From: Brian Banister <[REDACTED]>
Sent: 19 March 2025 12:58
To: Planning.Responses
Subject: Arun Conservation Area Advisory Panel comments on applications

The **Arun Conservation Area Advisory Panel** wish the following comments to be taken into consideration in the determination of the applications:

BR/32/25/PL - Trevali Lodge, 31 Aldwick Road, Bognor Regis

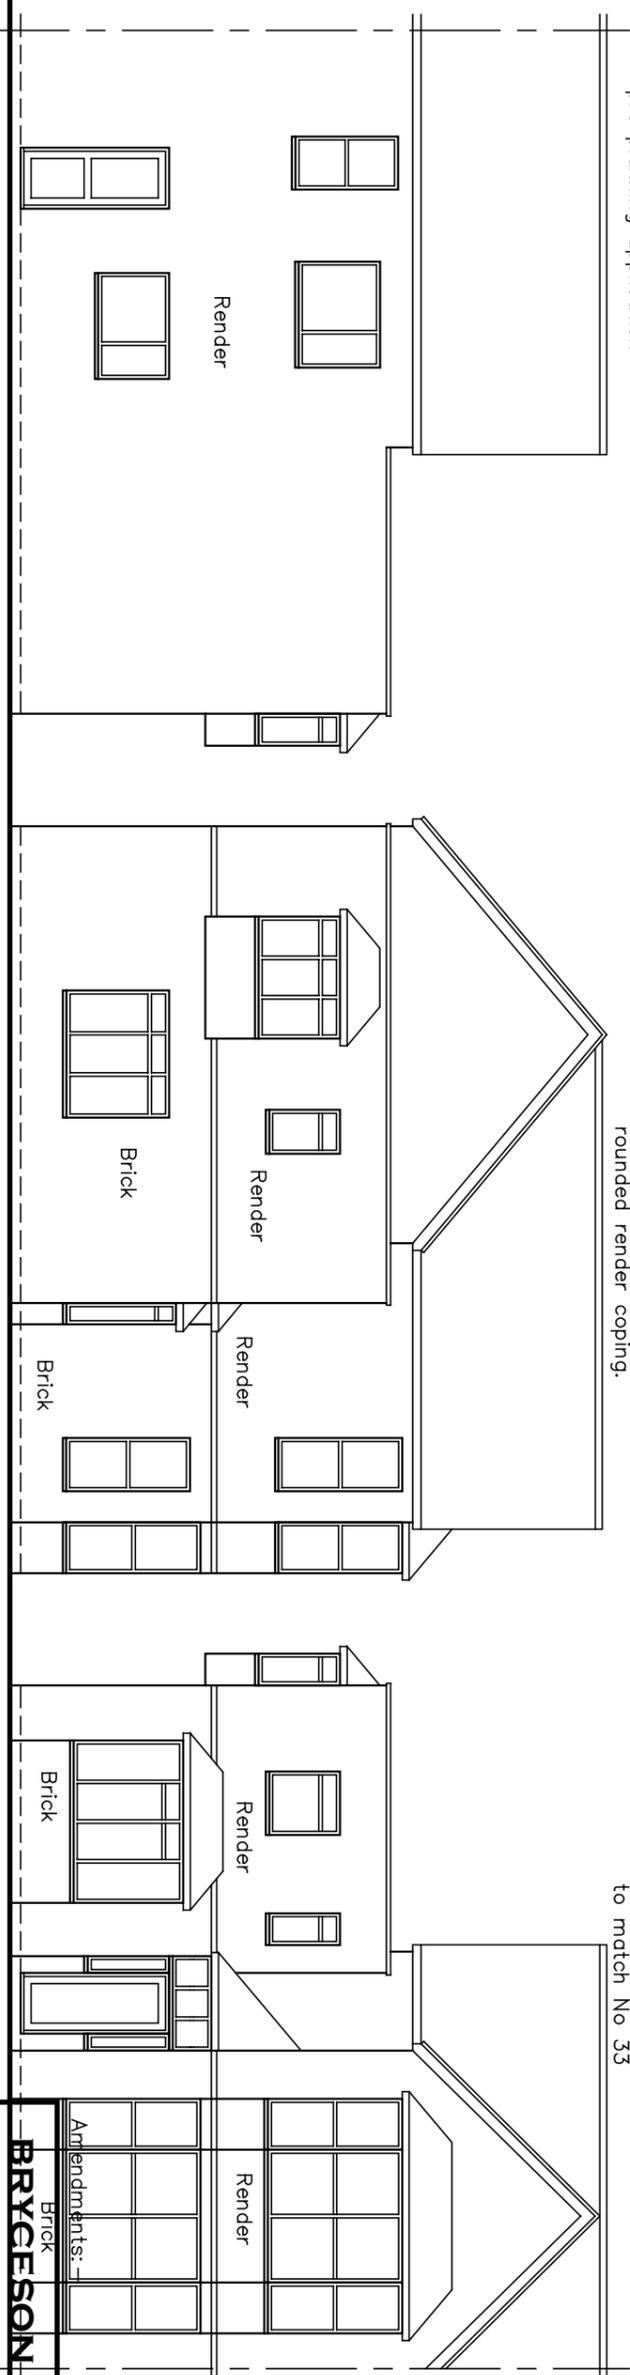
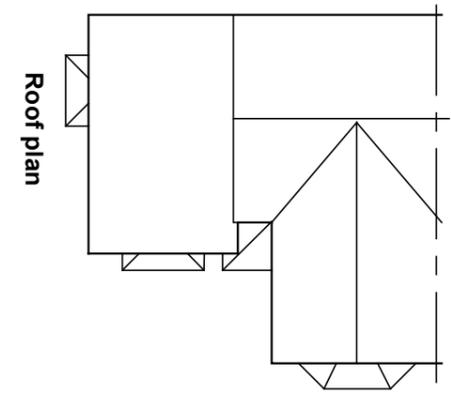
The existing windows on the principal facade are painted timber vertically sliding sashes and, as such, they are important traditional features which should be repaired or replaced 'like for like' in materials and operating mechanism (they could include slimline double glazed panes). The loss of such traditional features is always detrimental to the appearance of a conservation area. The proposal to replace them even with pvcu vertically sliding sashes, and any others with pvcu, will detract from the appearance of the property and the conservation area.

The note on the left hand side of Dwg no 4090/01/06 rather ambiguously implies that soffits and fascias will be replaced in pvcu. This requires clarification because if it is the case then there will be the further loss of traditional features to the detriment of the building and the conservation area. Timber soffits, fascias and bargeboards can never successfully be replaced or encased with pvcu without losing the subtlety of shape, form, proportions and texture of the originals.
